El Parador Multi-Family Development 201 Yale Blvd SE

Traffic Circulation Layout Responses to Review Comments August 24, 2021

This memo addresses the review comments for the TCL. Revised Traffic Circulation Layout dated 8/17/21 includes the following comments:

TRAFFIC CIRCULATION LAYOUT  
APPROVED

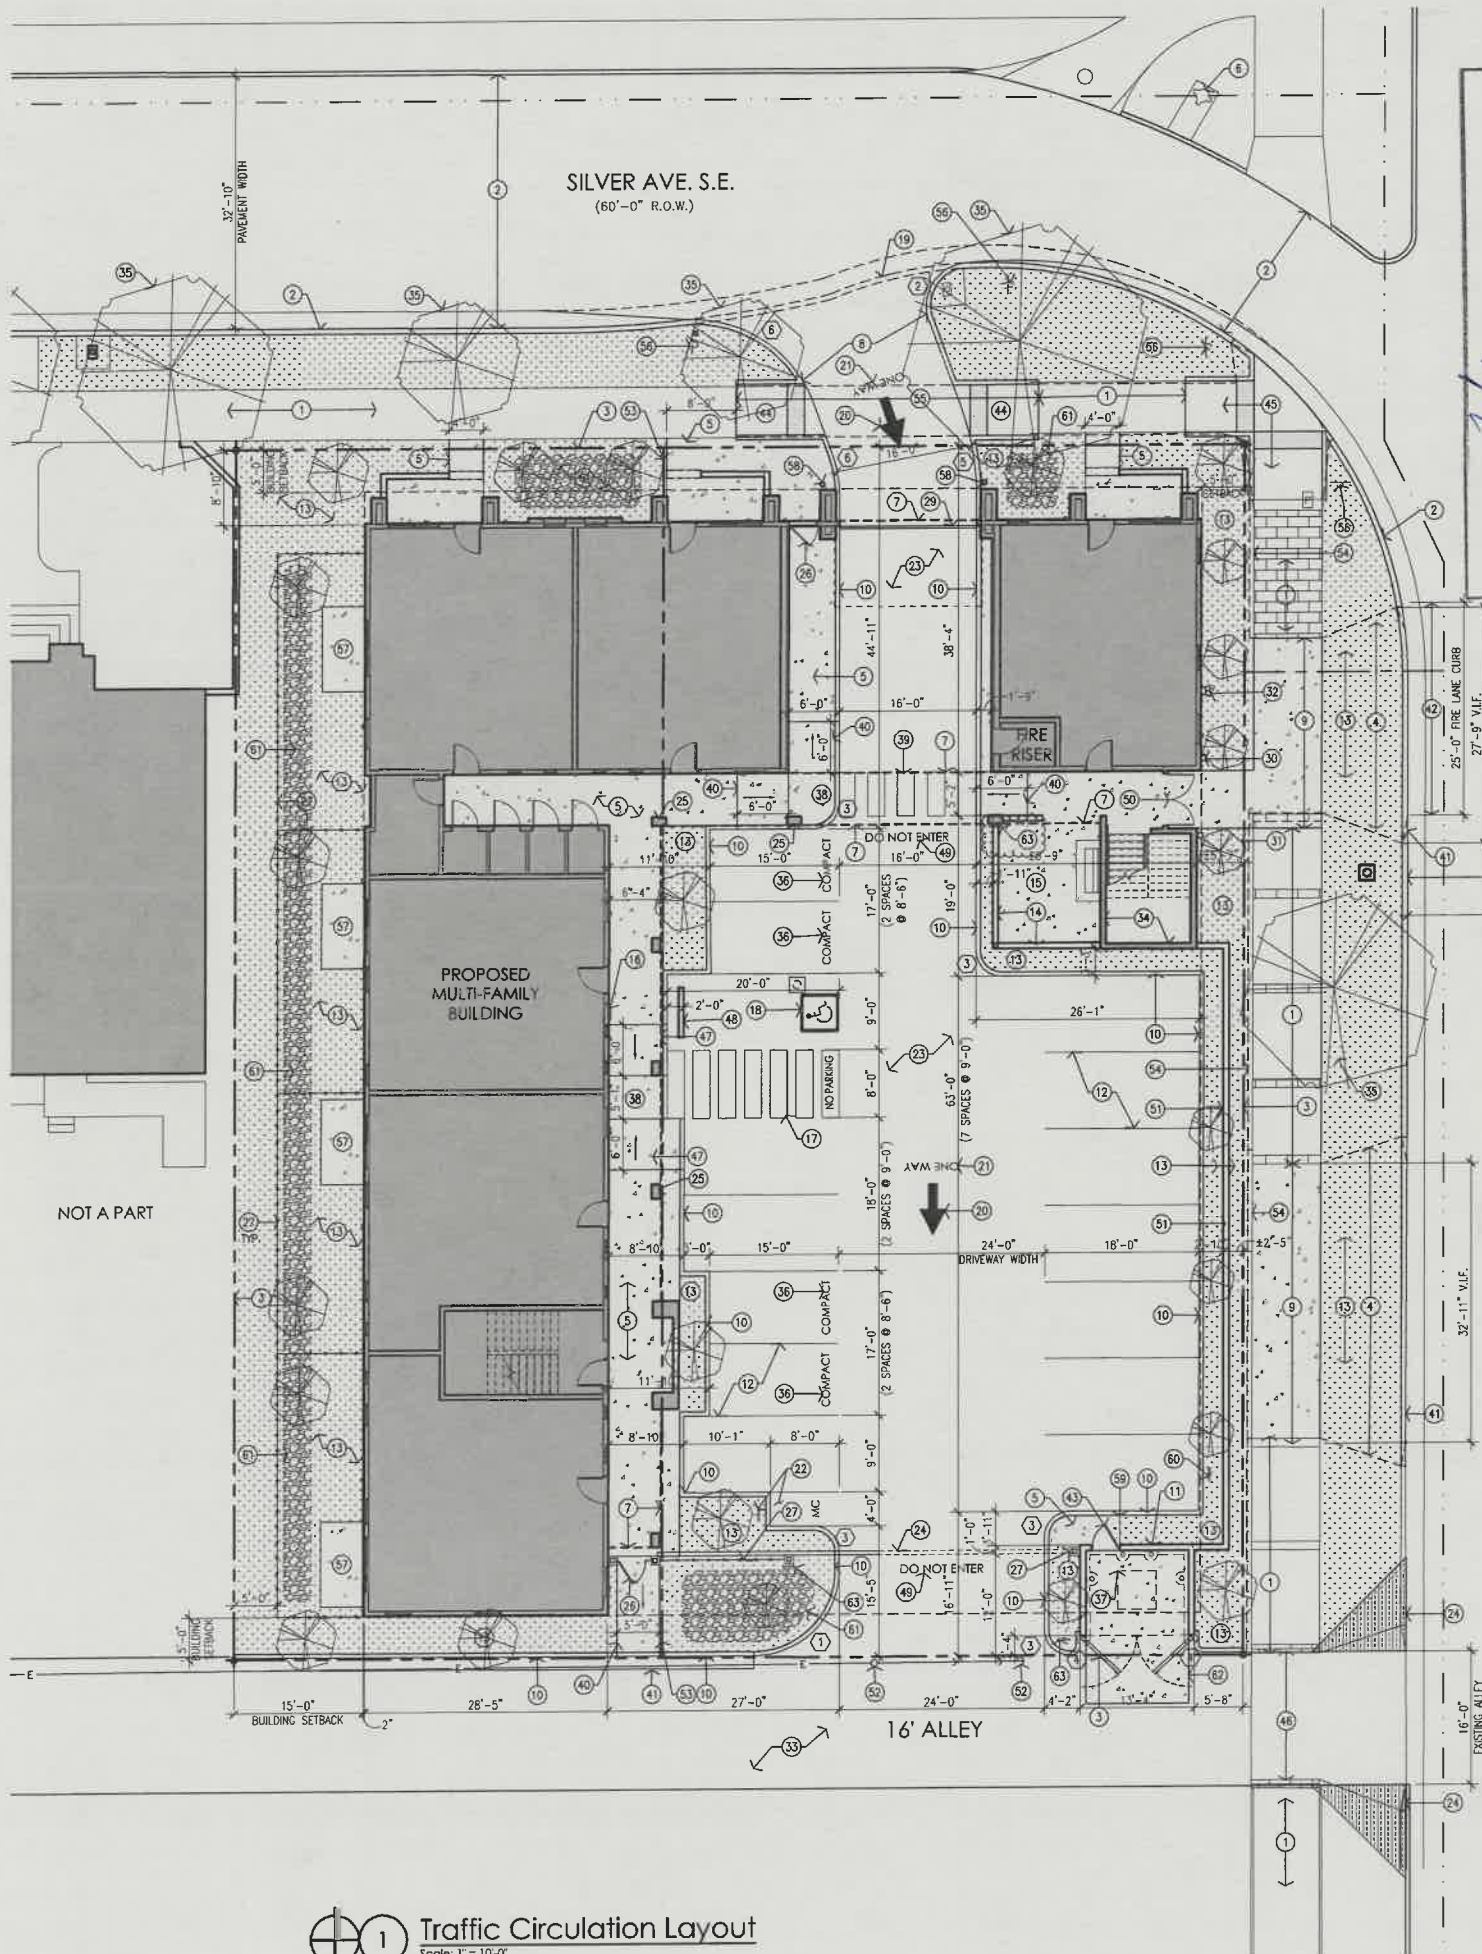
2. The proposed driveway off Silver Ave is too close to Yale Blvd and will not be accepted. Please adjust site plan. Yale is classified as a Minor Arterial per DPM the location of the driveway should be 200 ft from Yale Ave.
MHA Response:
Per discussion with Mr. Salgado-Fernandez, location of proposed driveway off of Silver Ave SE is acceptable.

4. Keyed Note 5 (Silver Ave. entrance): The arrow is pointed at proposed curb and gutter. Please adjust.
MHA Response:
Keynote 5 arrow adjusted to new concrete sidewalk.

5. Keyed Note 20 & 21: Pavement marking details will be needed at entrance and end of entrance will need another pavement marking which states Do Not Enter. This needs to be located at end of throat depth of entrance into parking lot and at end of parking lot (adjacent/end to proposed gate).
MHA Response:
Added new Keynote 49: 'DO NOT ENTER' pavement markings at the end of the driveway throat near the parking spaces and at the exit to the alley.

6. Keyed Note 25: You are showing proposed sidewalk adjacent to proposed ADA ramp slope and transitions. This situation is a tripping hazard for ADA pedestrians. Please clarify this safety concern.
MHA Response:
Proposed ADA curb ramp revised per COA parallel curb ramp configuration. Refer to MHA comment response 11 below for additional information.

7. Keyed Note 26: Pedestrian access gate needs to be 6 ft in width per ADA pedestrian pathway requirements (Silver Ave entrance driveway).
MHA Response:
A 6'-0" site pedestrian access gate is indicated located off of Yale Blvd NE. New keynote 50 reads: "NEW 6'-0" DOUBLE PEDESTRIAN ACCESS GATE."

8. Keyed Note 38: This read 2% max. slope on landing.
MHA Response:
Revised Keynote 38: "THIS AREA FLUSH WITH ASPHALT PAVING, 2% MAX. SLOPE AT CURB RAMP LANDING."

9. Keyed Note 39: Provide the color of striping for proposed cross walk pavement markings.
MHA Response:
Revised Keynote 39: "NEW 2'-0" x 6'-0" PAINTED WHITE CROSSWALK STRIPING."

10. Keyed Note 42: Specify the color of Paint for Fire Lane.
MHA Response:
Revised Keynote 42: "EXTENTS OF FIRE LANE CURB - PAINTED RED PER AFD."
11. Keyed Note 44:

- Call out COA std dwg 2442 instead of 2441 for this type of unidirectional ramp.MHA Response:
Revised Keynote 44: "NEW CITY STANDARD PARALLEL CURB RAMP PER COA DETAIL 2443-C. WITH TRUNCATED DOMES PER COA STD DWG."

- Silver Ave: All portions of proposed ADA ramp SHALL be located within public ROW.MHA Response:
Proposed COA parallel curb ramp layout stays within the public right-of-way.

12. Keyed Note 46: Provide the alley pavement design.
MHA Response:
Revised Keynote 46: "EXTENTS OF NEW ALLEY PAVEMENT CAPABLE OF SUPPORTING IMPOSED LOAD OF FIRE APPARATUS PER AFD." Additional pavement specifications will be provided on the forthcoming Grading & Drainage Plan.

15. ADA curb ramps must be updated to current standards and have truncated domes installed located within public ROW. This includes Keyed Note 45.

17. Motorcycle parking space: Label pavement MC.

26. All one-way drives shall have "One Way" and "Do Not Enter" signage and pavement markings. Please show detail and location of posted signs and striping.
MHA Response:
Revised plan indicated "ONE WAY" and "DO NOT ENTER" pavement markings at property entry and exit.

All curb ramps located in the right-of-way are indicated to have truncated domes. Keynote 44 has been revised to read: "NEW CITY STANDARD PARALLEL CURB RAMP PER COA DETAIL 2443-C WITH TRUNCATED DOMES PER COA STD DWG." Keynote 45 has been revised: "NEW CITY STANDARD PARALLEL CURB RAMP PER COA DETAIL 2445-B WITH TRUNCATED DOMES PER COA STD. DWG."

The motorcycle space is noted with "MC" and revised Keynote 22 reads: "NEW MOTORCYCLE PARKING (4'x8') WITH 4" WIDE x 12" HIGH WHITE PAVEMENT LETTERING AND SIGNAGE. REFER TO 3/A002."
